**Consultation Response from KC,
Trees**
2026/90255 Wye, Wheelwright Drive, Dewsbury, WF13 4JB
Demolition of bungalow and erection of detached dwelling with integral double garage
Date Responded: 29/07/2026
Responding Officer: Hazel Irving
Responding Ref: 12/08

Project Title
proposed site

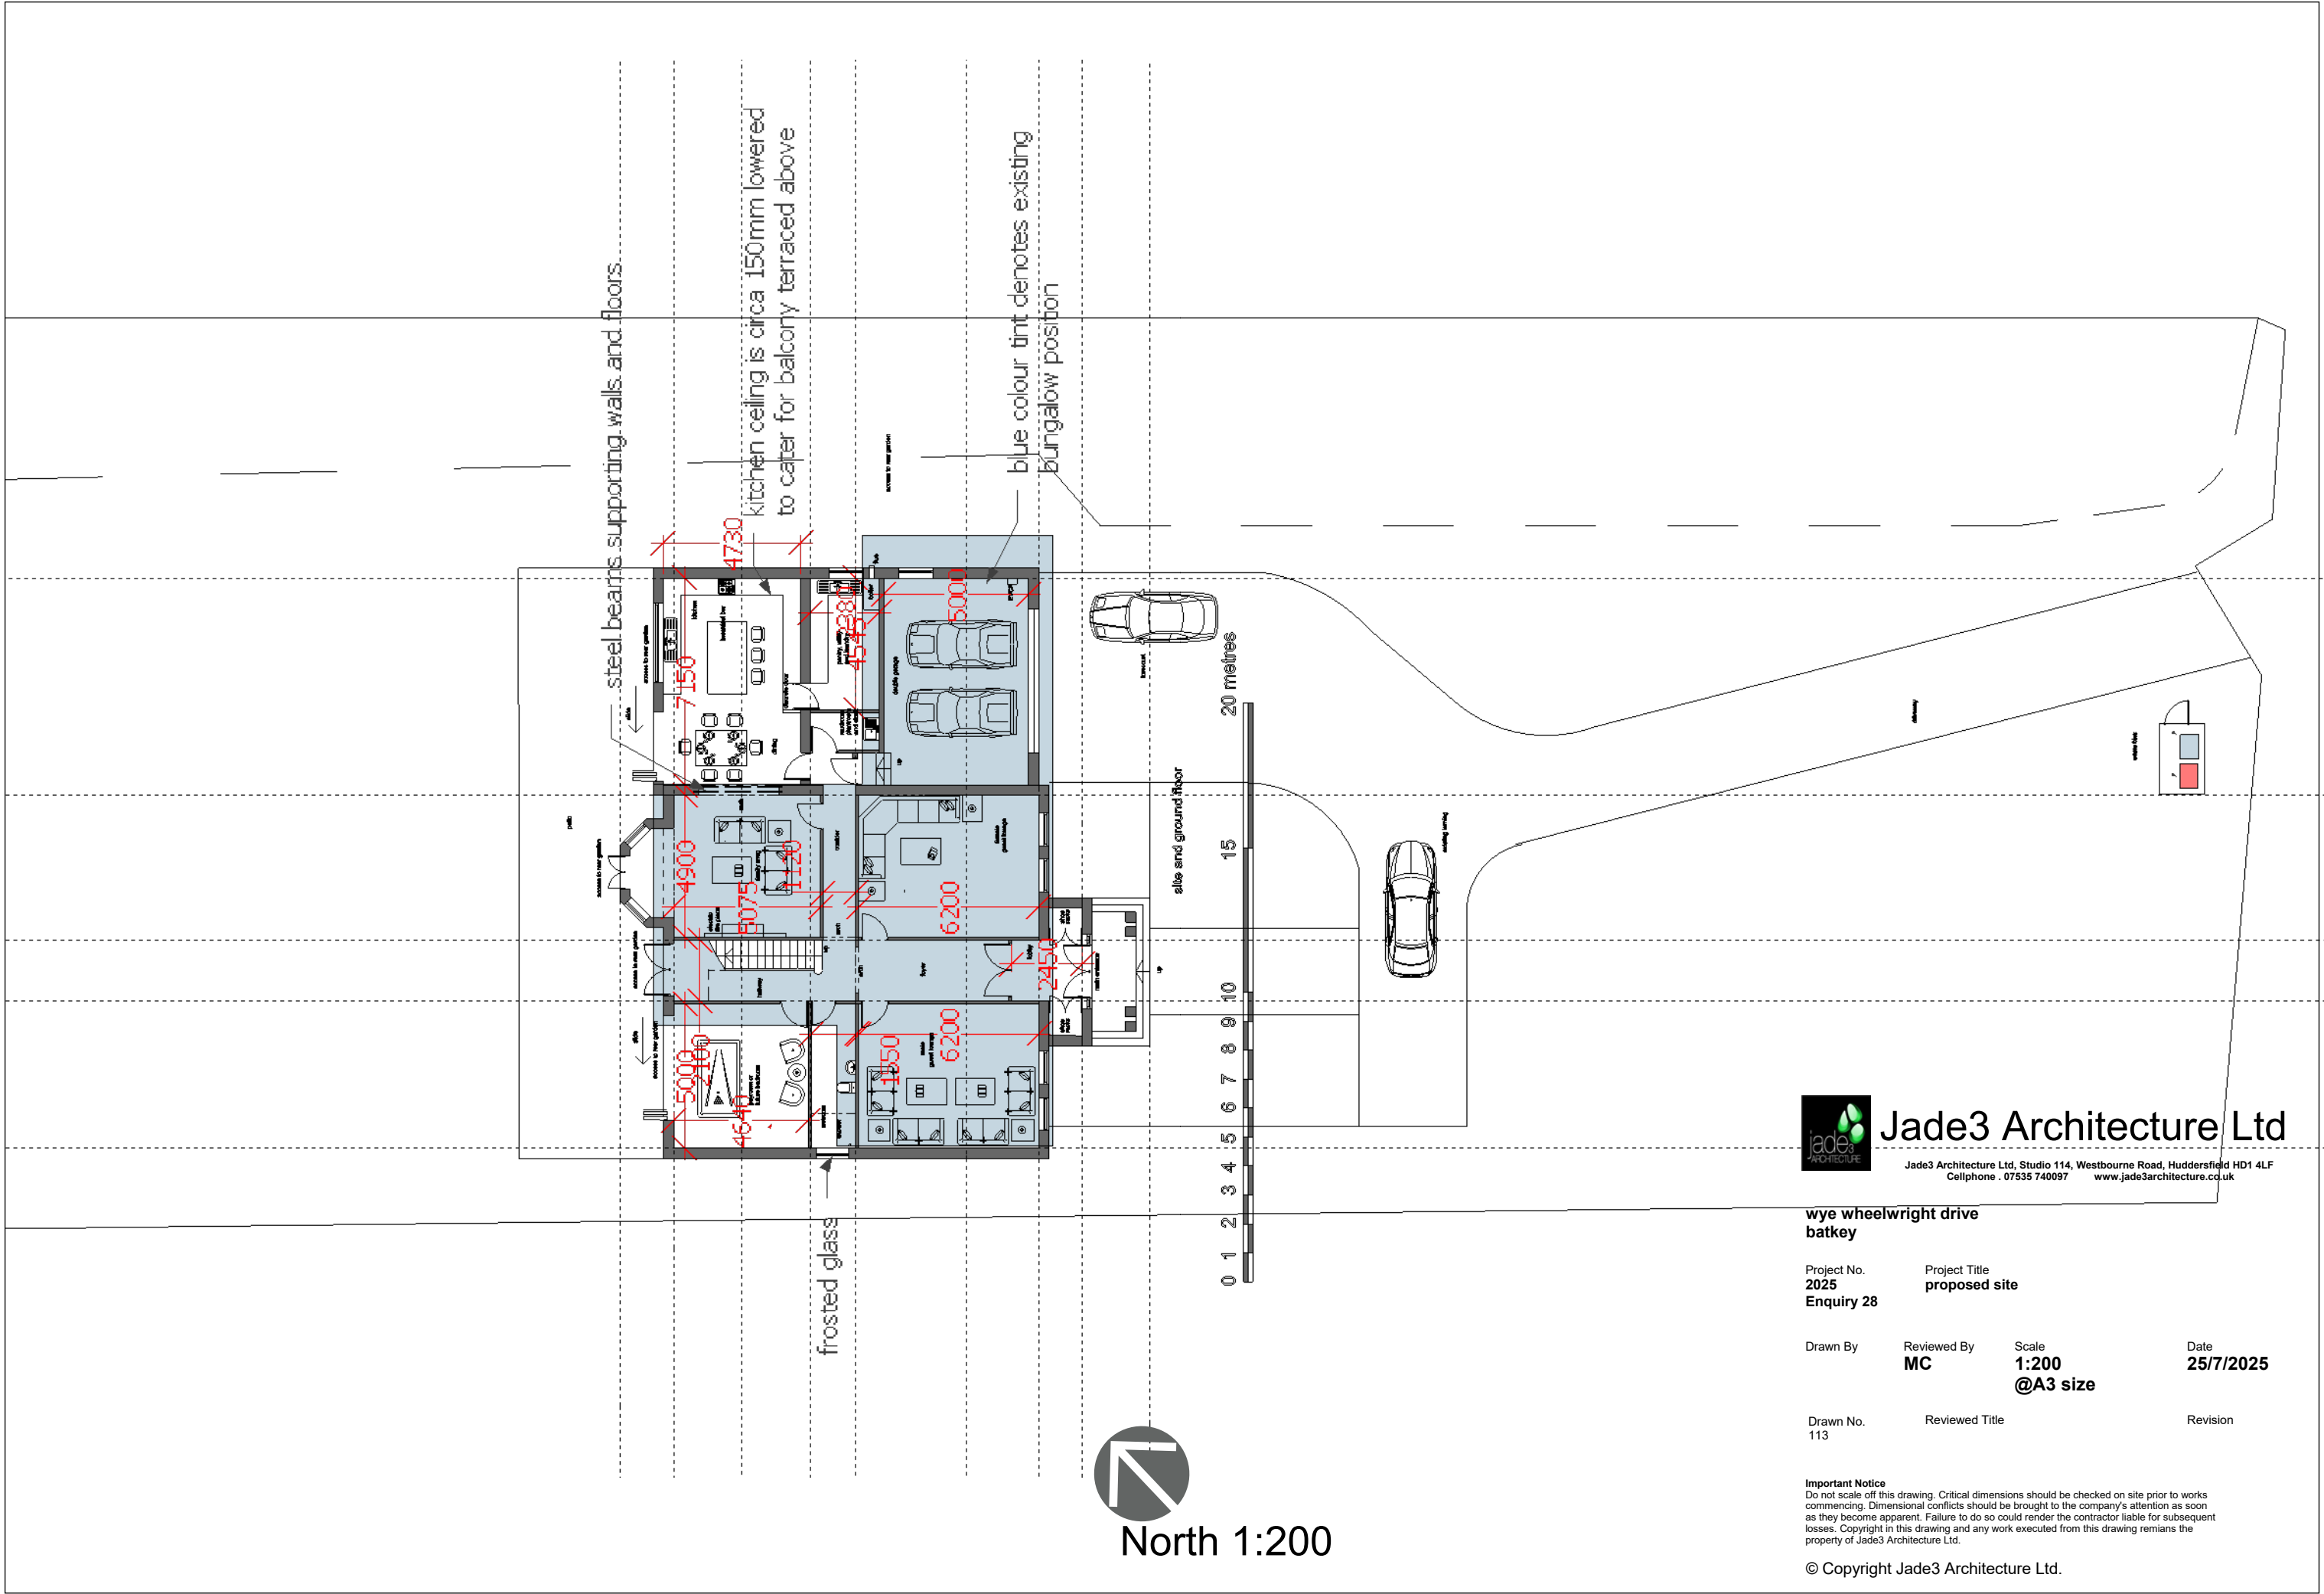
The demolition work as well as multiple elements of the construction proposals, including the bin store, replacement garage, dwelling and patio, would likely impact trees protected by a TPO. Essential details of the proposed construction remain unspecified. Therefore, conditions are required to ensure that the health of retained trees is not threatened by the development, should planning permission be granted. This is to ensure that the development meets the requirements of National Planning Policy and Local Plan Policies LP33 and LP24:

Development shall not commence until an updated Arboricultural Impact Assessment and Arboricultural Method Statement, has been submitted to, and approved in writing by the Local Planning Authority. The impact assessment shall include details of all likely impacts to trees which may be impacted by the proposed development, including any proposed drainage and services layouts. The method statement shall include specific details on how the demolition and construction work will be undertaken to minimise damage to the retained trees. This must include details of any specialist construction methodologies required to reduce impacts to retained trees.

All required work within or immediately adjacent to RPAs or canopies of retained trees is to be undertaken under the direct on-site supervision of an arboriculturist. A record of all arboricultural monitoring and supervision visits will be kept, and any faults will be logged, this will then be copied to the site agent, developer and local planning authority tree officer in a digital format.
